SSD 7047

Response to Submissions and Amended Proposal

Interactive Display System - SICEEP

Sept 2016 ■ 15048

6 DIGITAL SIGN T17 WEST ELEVATION

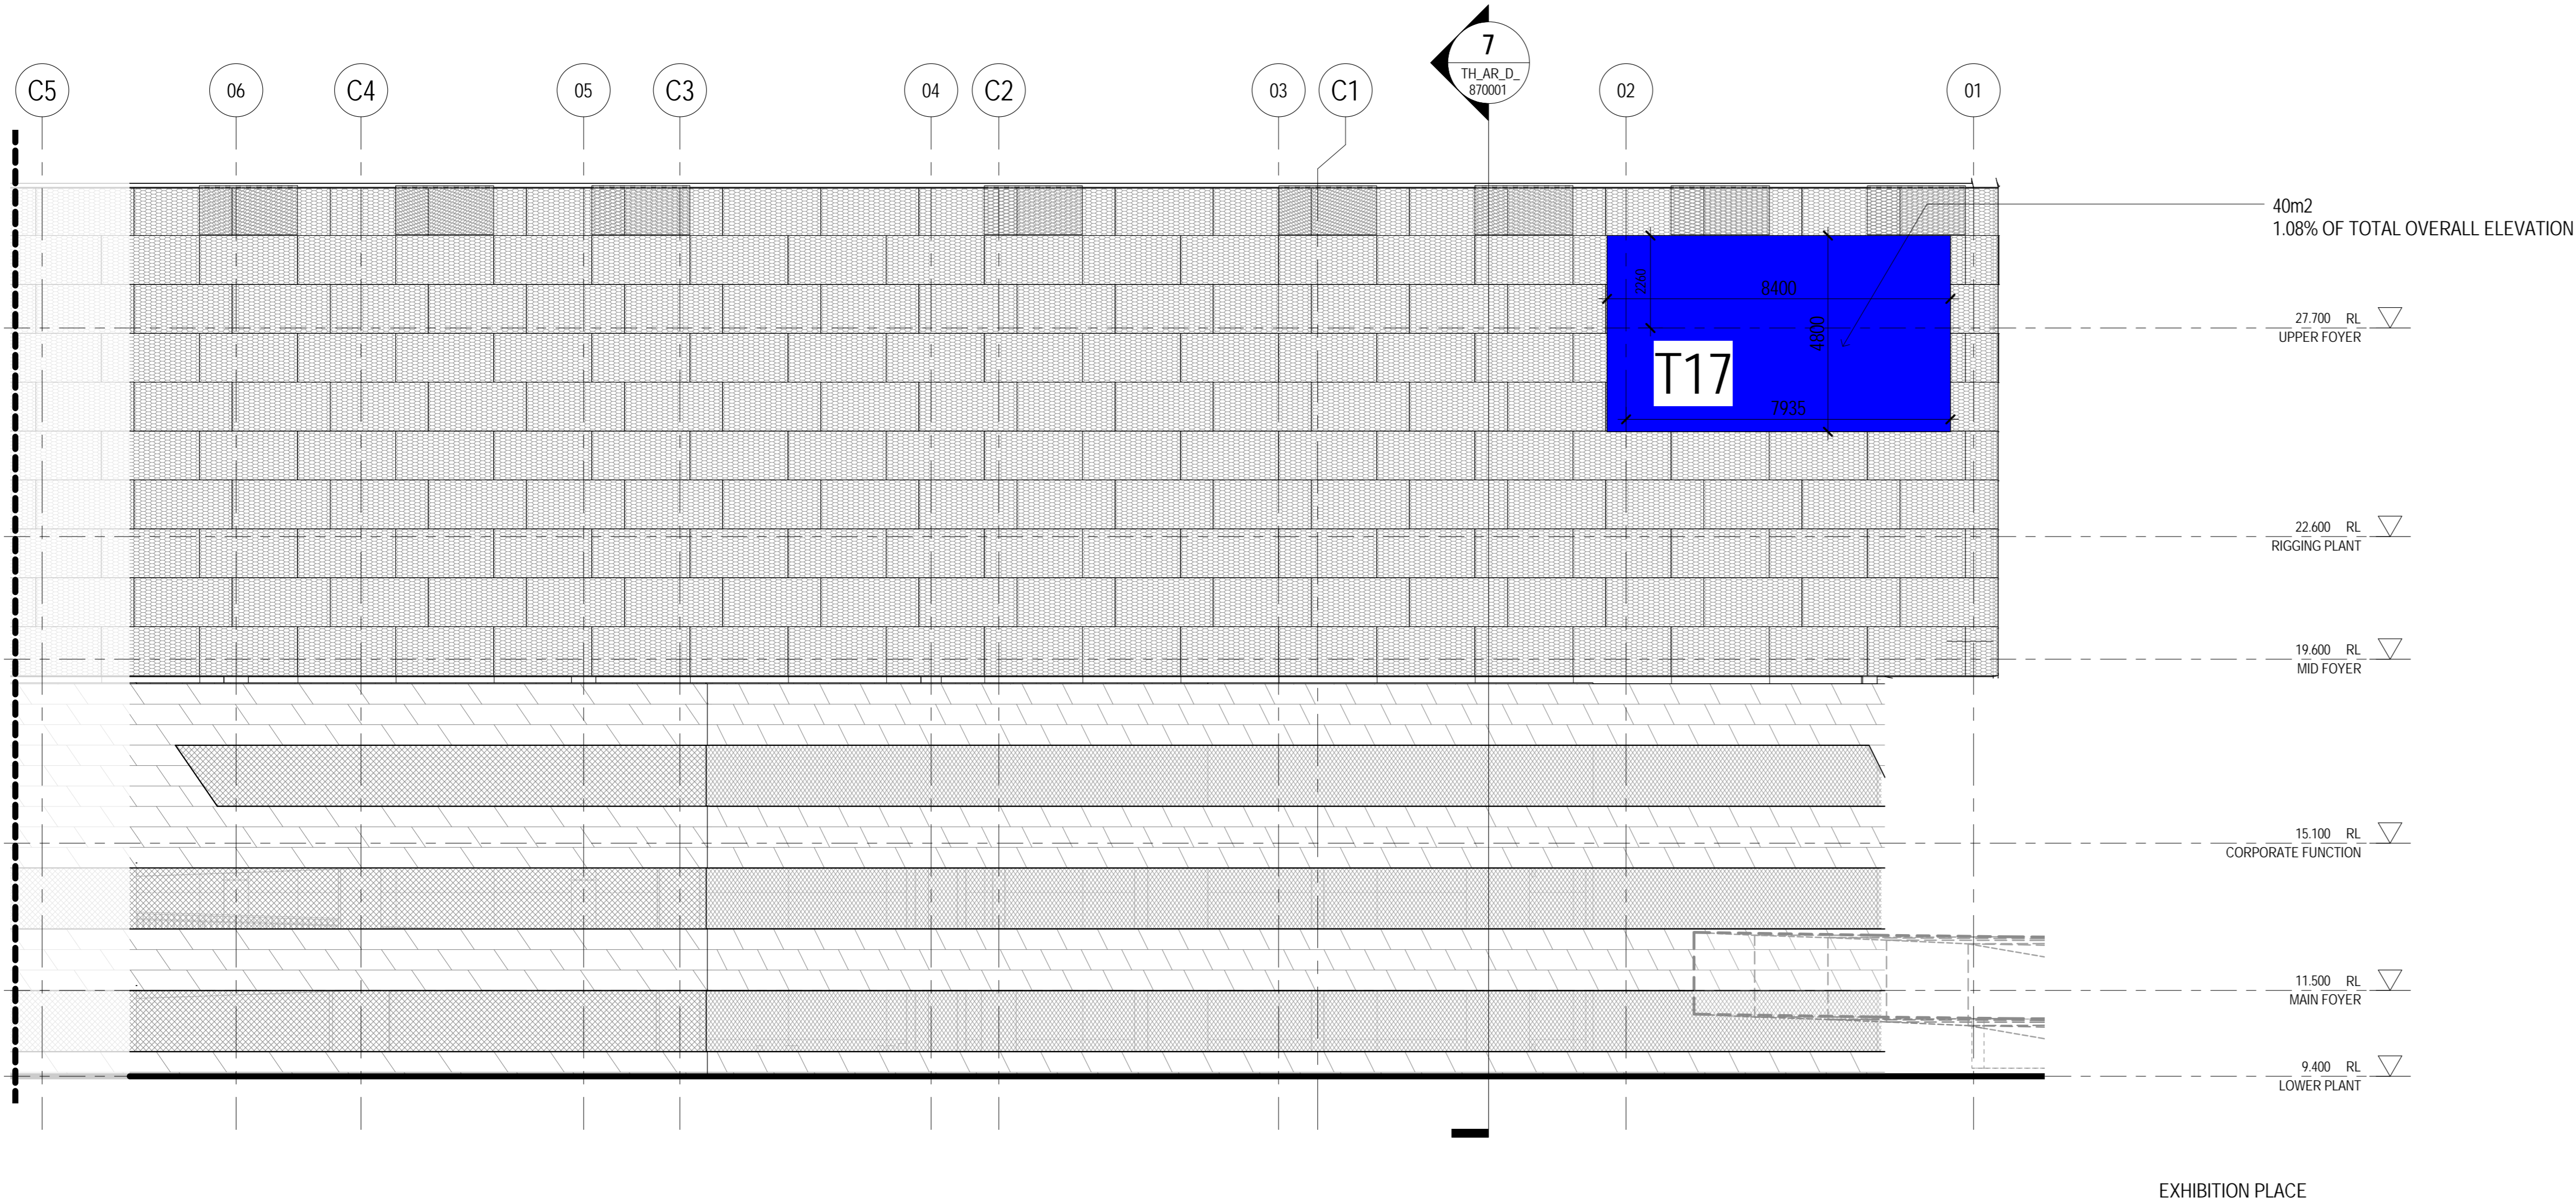
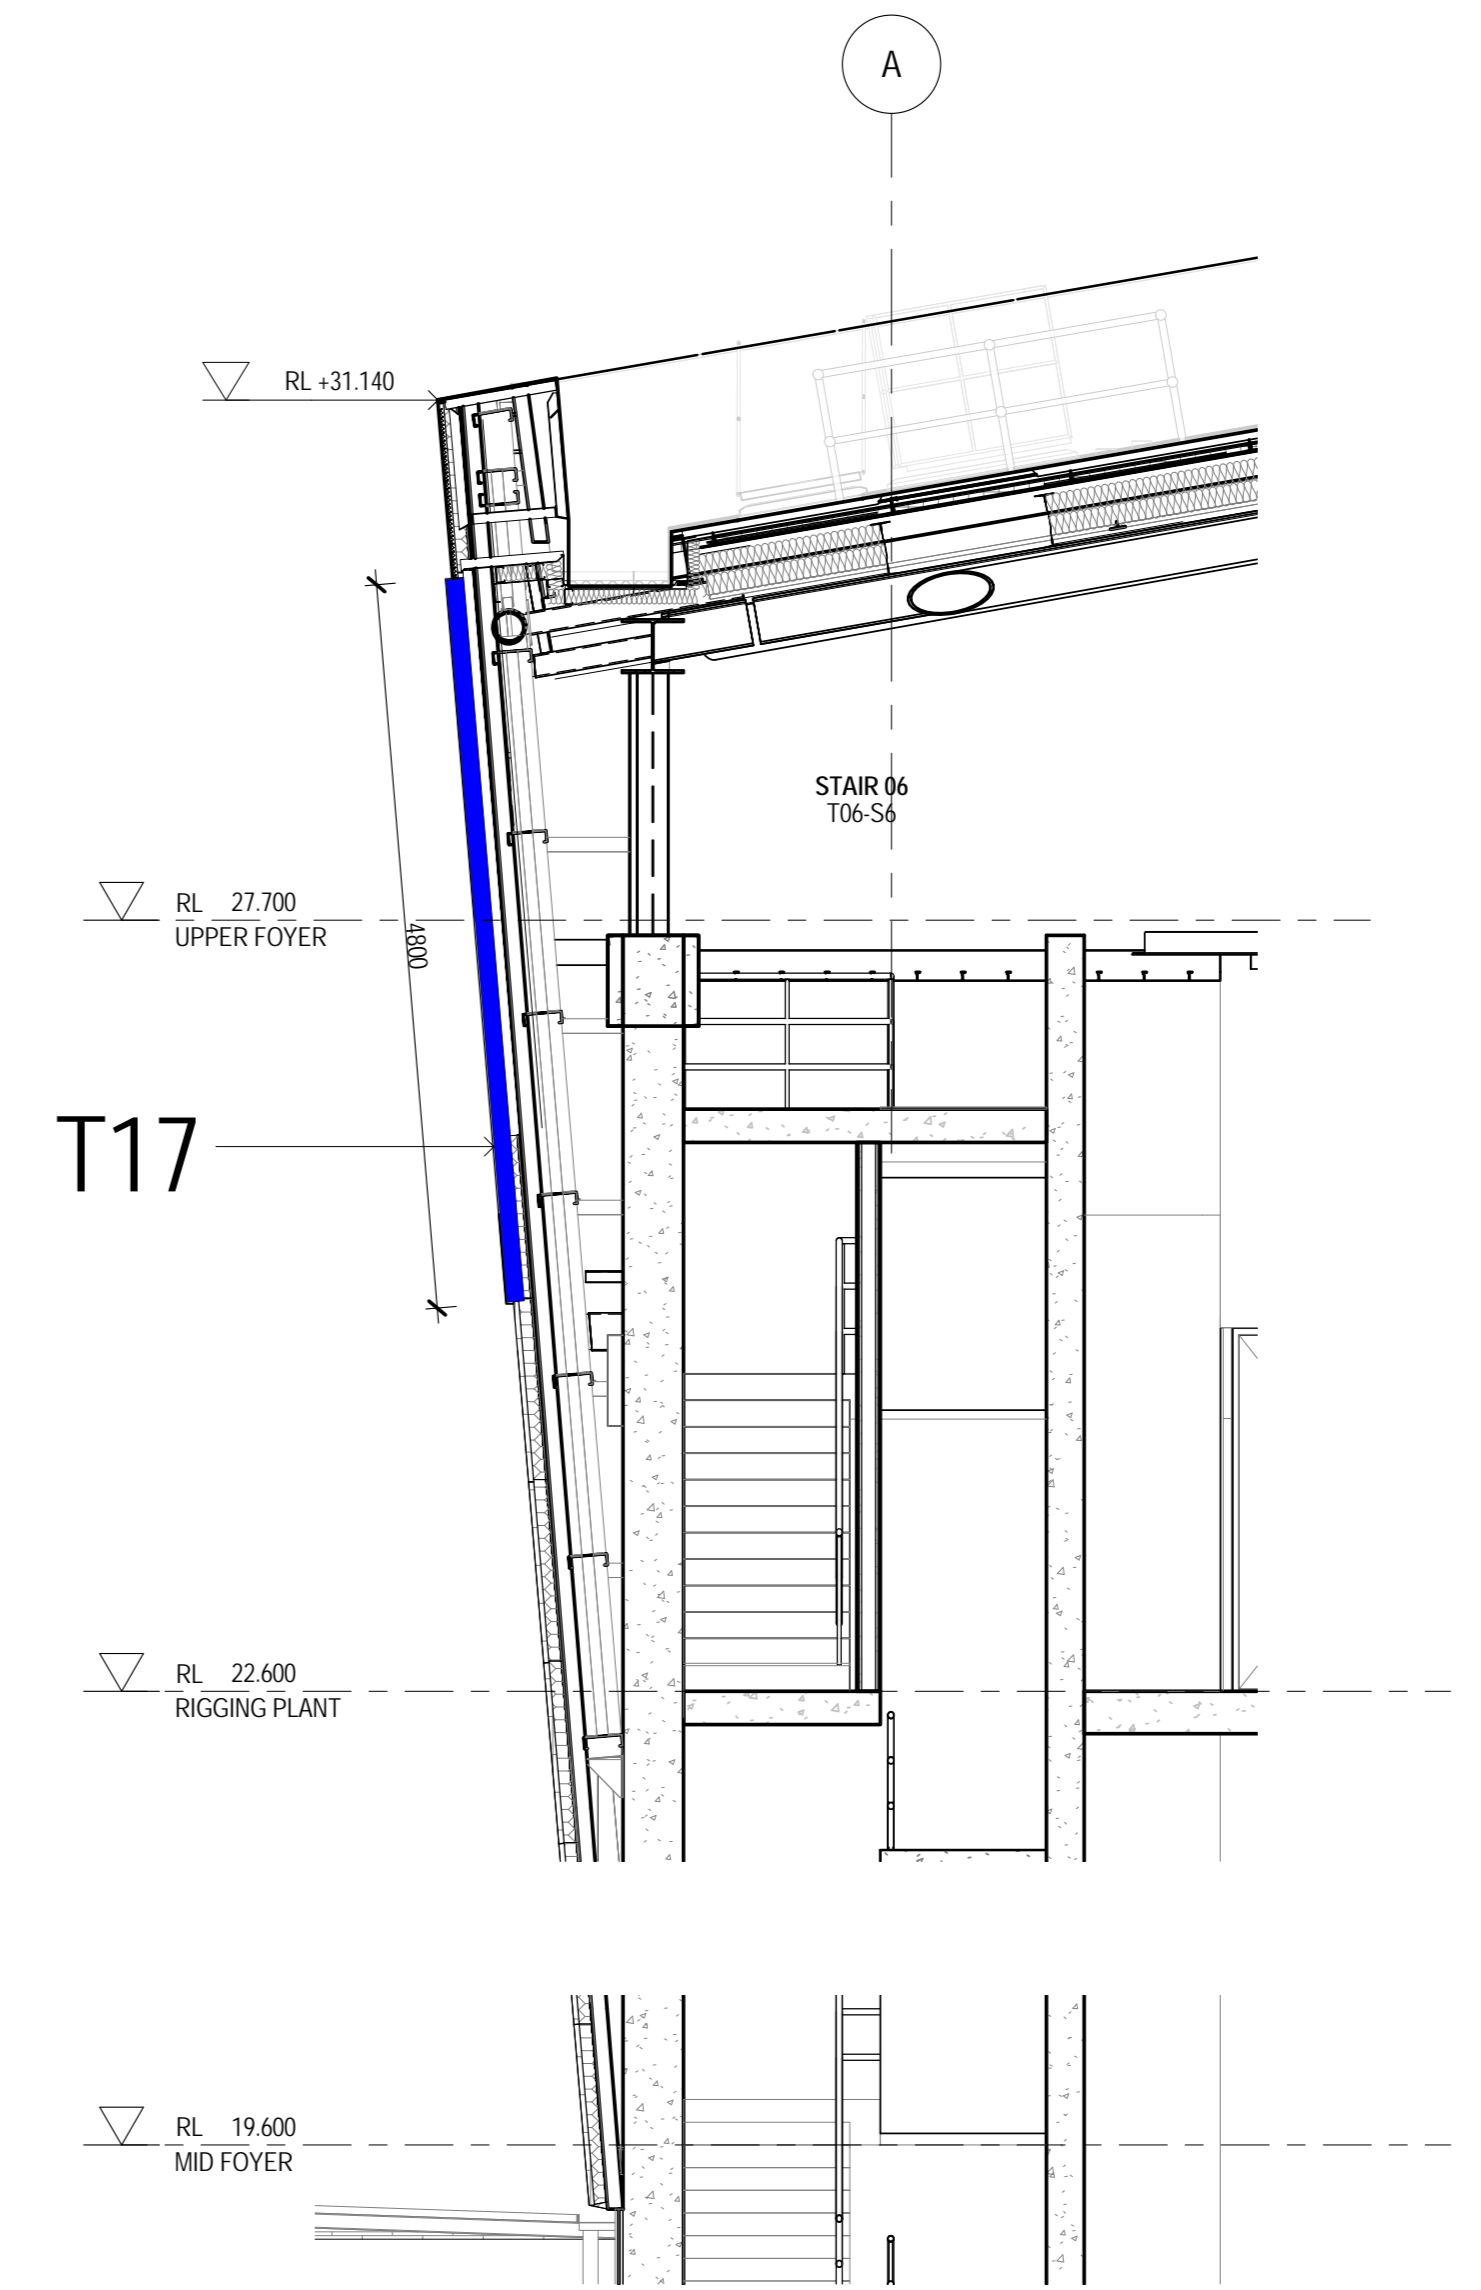
The Department requested that a cumulative road safety assessment to be conducted for Sign T17 noting that an electronic advertisement has also been approved facing Pier Street for the North West plot. This additional report was prepared by ARRB and is provided as **Appendix F**.

The display area of T-17 is proposed to be reduced in size from 85m² to 40m². Following this reduction in size this element of the proposed development is no longer affected by Clause 19 of SEPP 64 and as such can be approved without a site specific DCP being in place. Amended plans reflecting the reduced T-17 sign is provided at **Appendix C**.
